# Planning Inspectorate

EN010158

15 December 2025

### Application by Rosefield Energyfarm Limited for an order granting development consent for the Rosefield Solar Farm

**SHEET 3 OF 8**

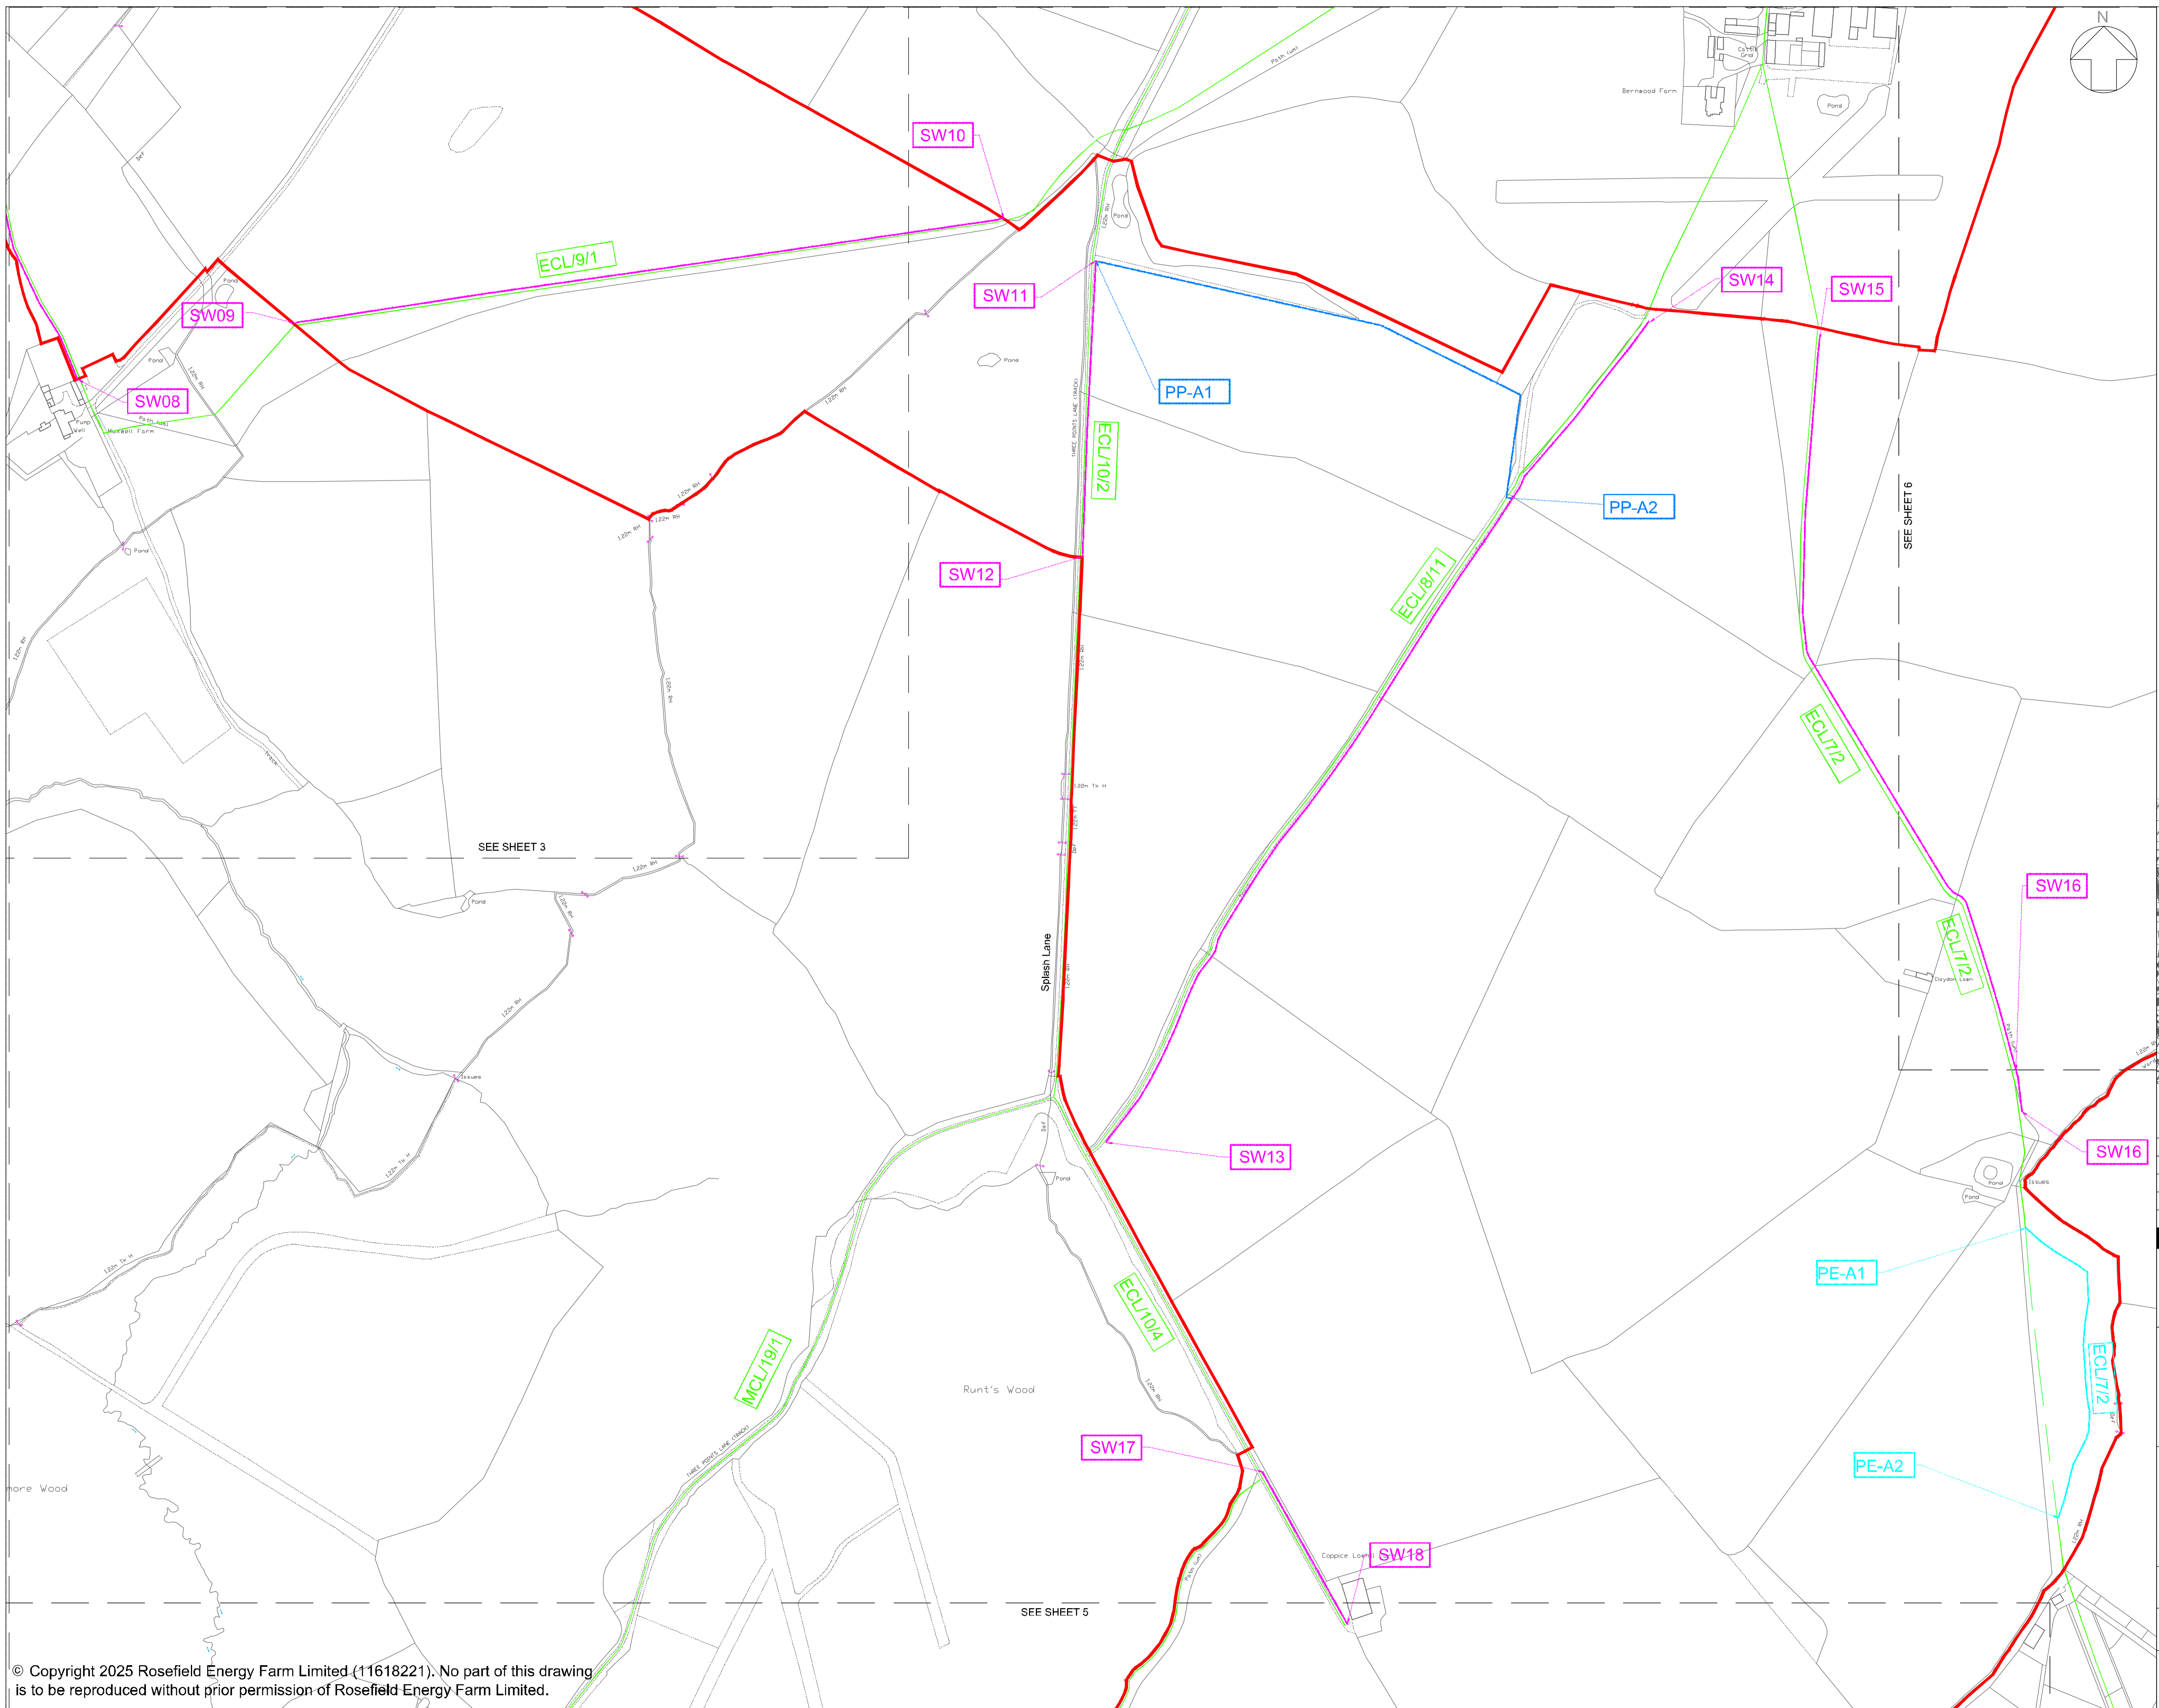
Annex 1 of the Outline Construction Traffic Management Plan (oCTMP) [\[APP-141\]](#) provides drawings of proposed road improvements and access junction layouts. The ExA notes that within Annex 1, figure SK009 that details road widening appears to show such works as being proposed outside of the order limits [\[AS-004\]](#). In addition, figure SK005 appears to show a proposed junction to the east of Three Points Lane into land that is also outside of the order limits. Both drawings contradict the corresponding plans in the Street, Rights of Way and Access Plans [\[AS-007\]](#), namely, sheets 3 and 8.

Clarify if any updates to the order limits may be required to facilitate the full extent of highways works as identified in the oCTMP. If so, also identify any implications for the compulsory acquisition or temporary possession of land. If the applicant considers that the necessary highways works can be implemented within the order limits as currently defined [AS-004], provide further clarification and updates to the oCTMP as required to demonstrate how they would be achieved.
